Addendum No. 3

RE: Contract # C204397

Rutherford County (R-2233BB)

US-221 SOUTH OF US-74 BUS (CHARLOTTE RD) TO NORTH OF SR-1366 (ROPER LOOP RD).

1 05/02/2022 ADDED RRFB'S
AND ADVANCE WARNING
FLASHING BEACONS
JTB

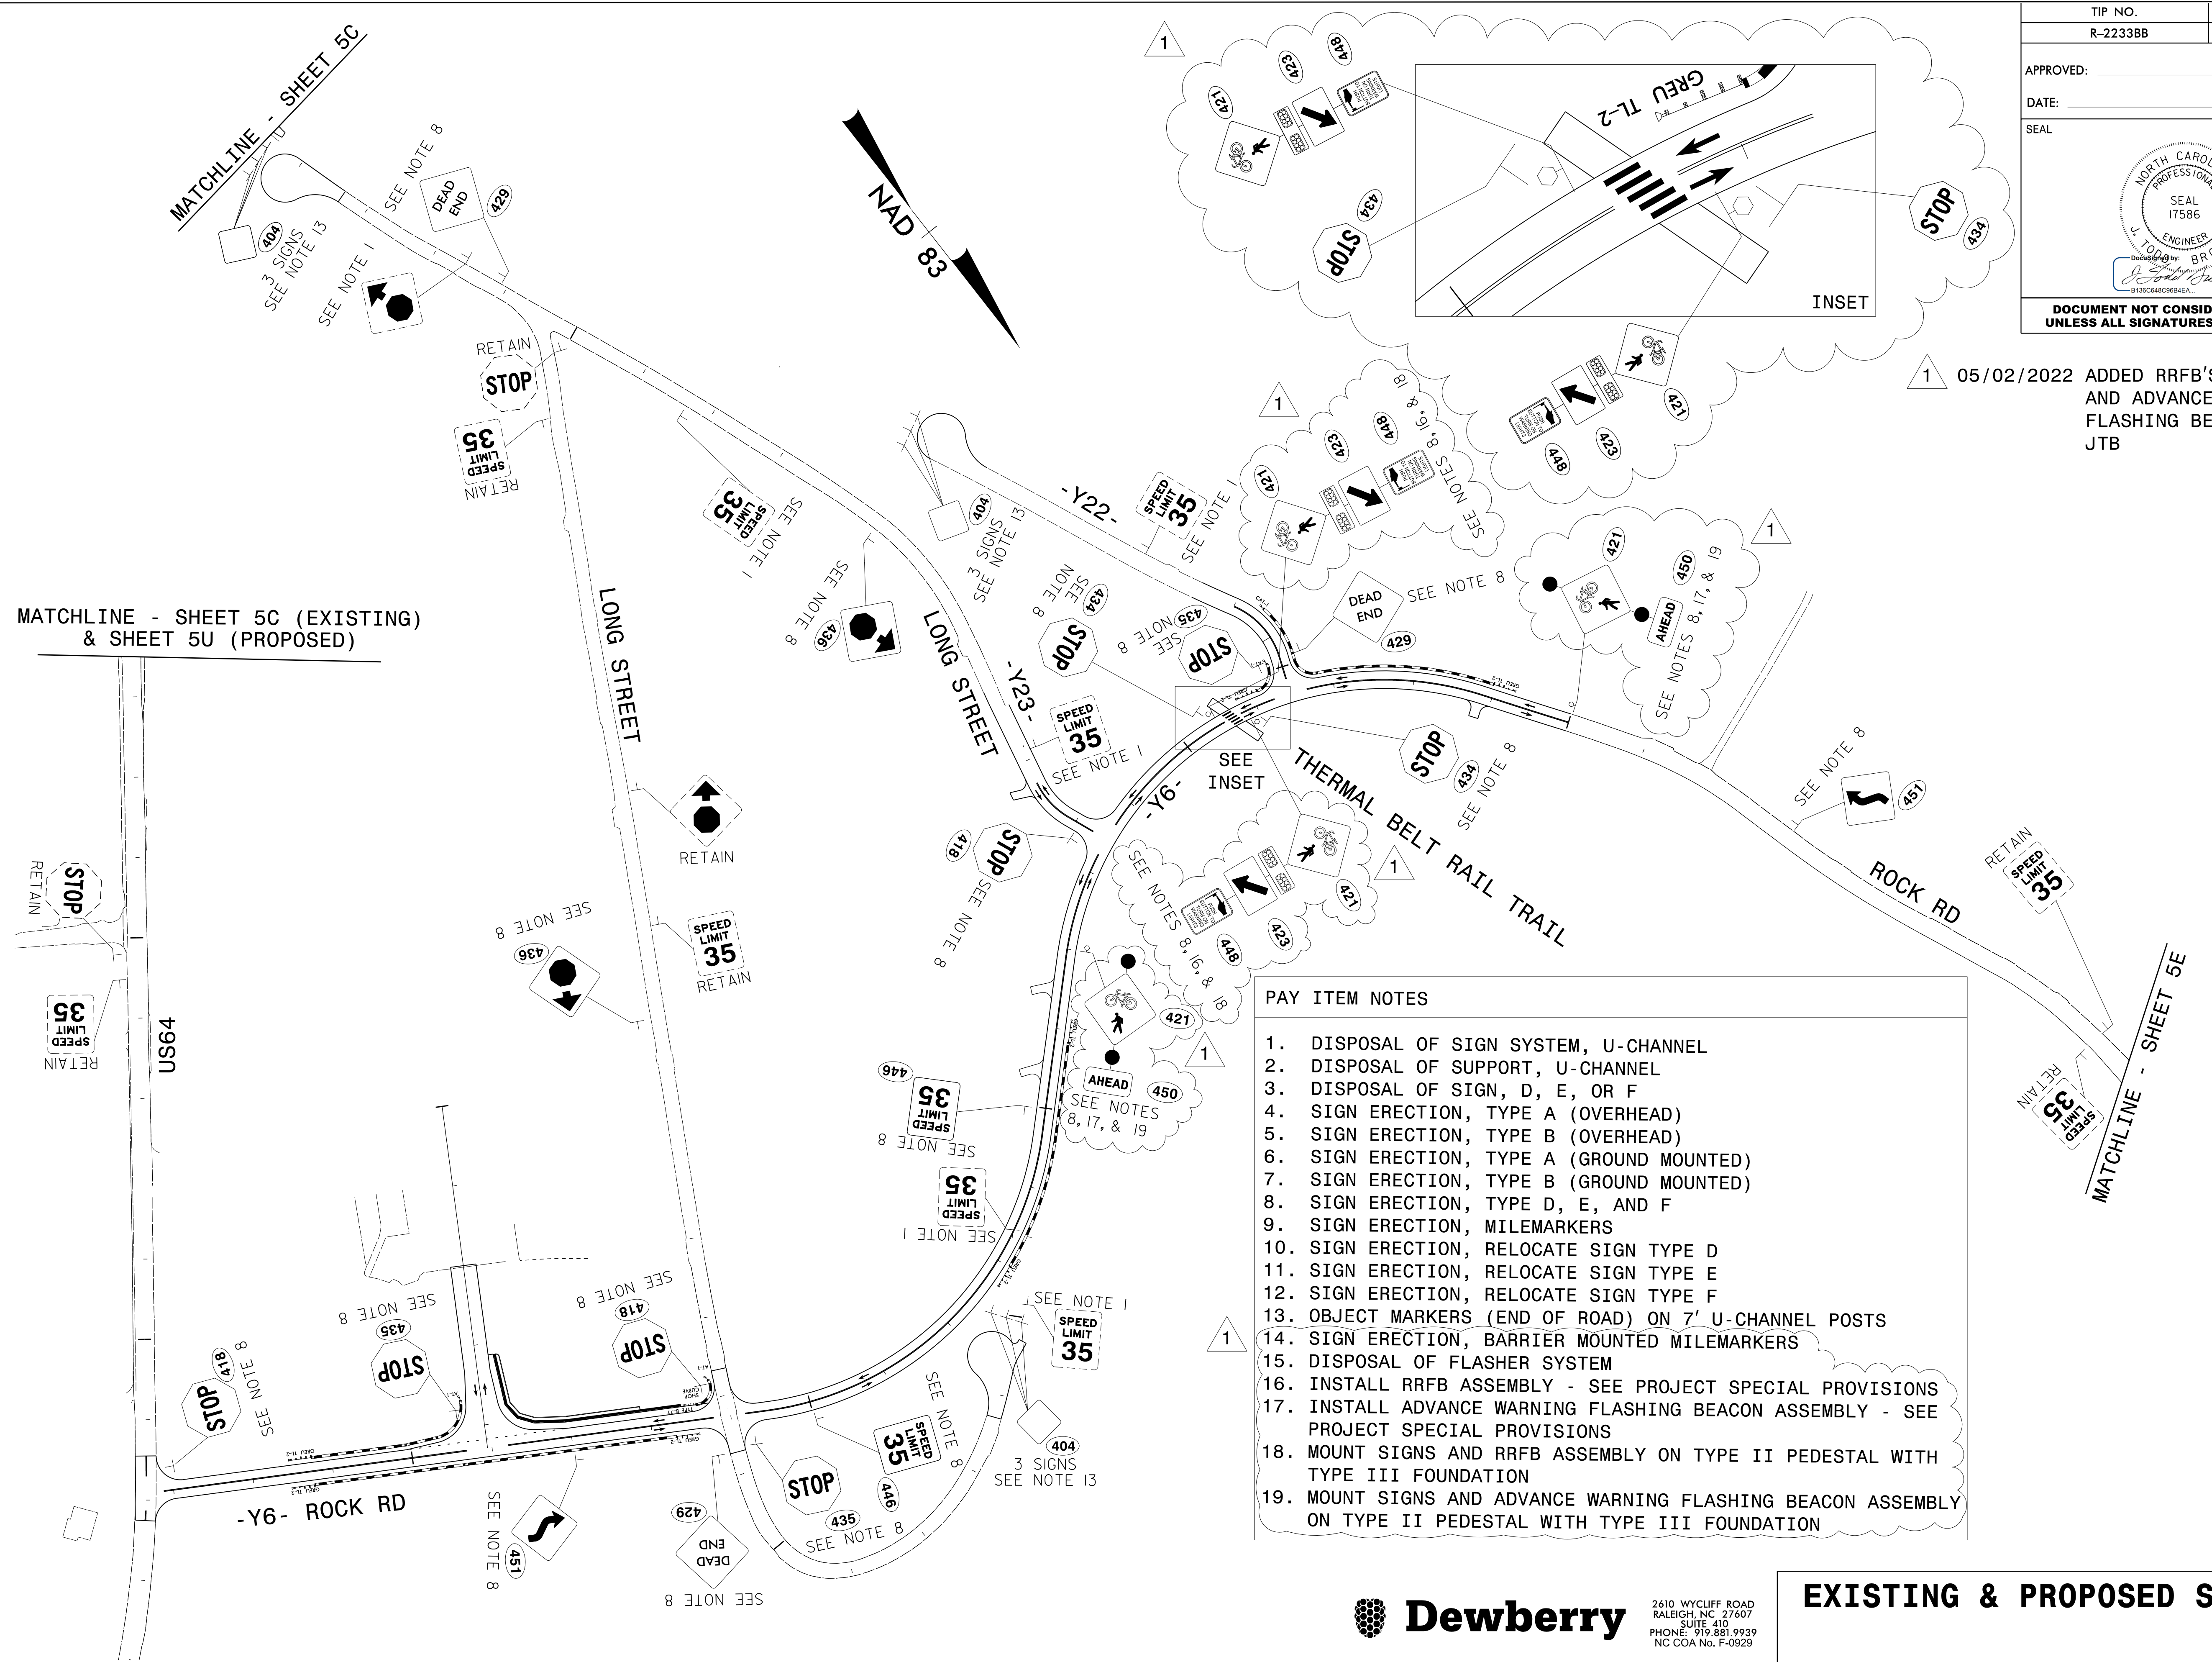
| Page No. | Revisions |
|---------------------------|---|
| SN-02 thru SN-08 (New) | Project Unit Special Provisions entitled RRFB (RECTANGULAR RAPID FLASHING BEACON) SOLAR POWERED and ADVANCE WARNING FLASHING BEACONS were added to the Signing Unit Special Provisions. |

For each approach to the RRFB location, install two RRFB assemblies at the crosswalk, one on the right-hand side of the roadway and one on the left-hand side of the roadway as shown on the Plans. Install the RRFB on the same support as the associated W11-15 (Bicycle/Pedestrian Crossing), W11-15P (TRAIL X-ING)) and W16-7P (Downward Diagonal Arrow) warning signs and plaques. Do not install an RRFB independent of the crossing warning signs.
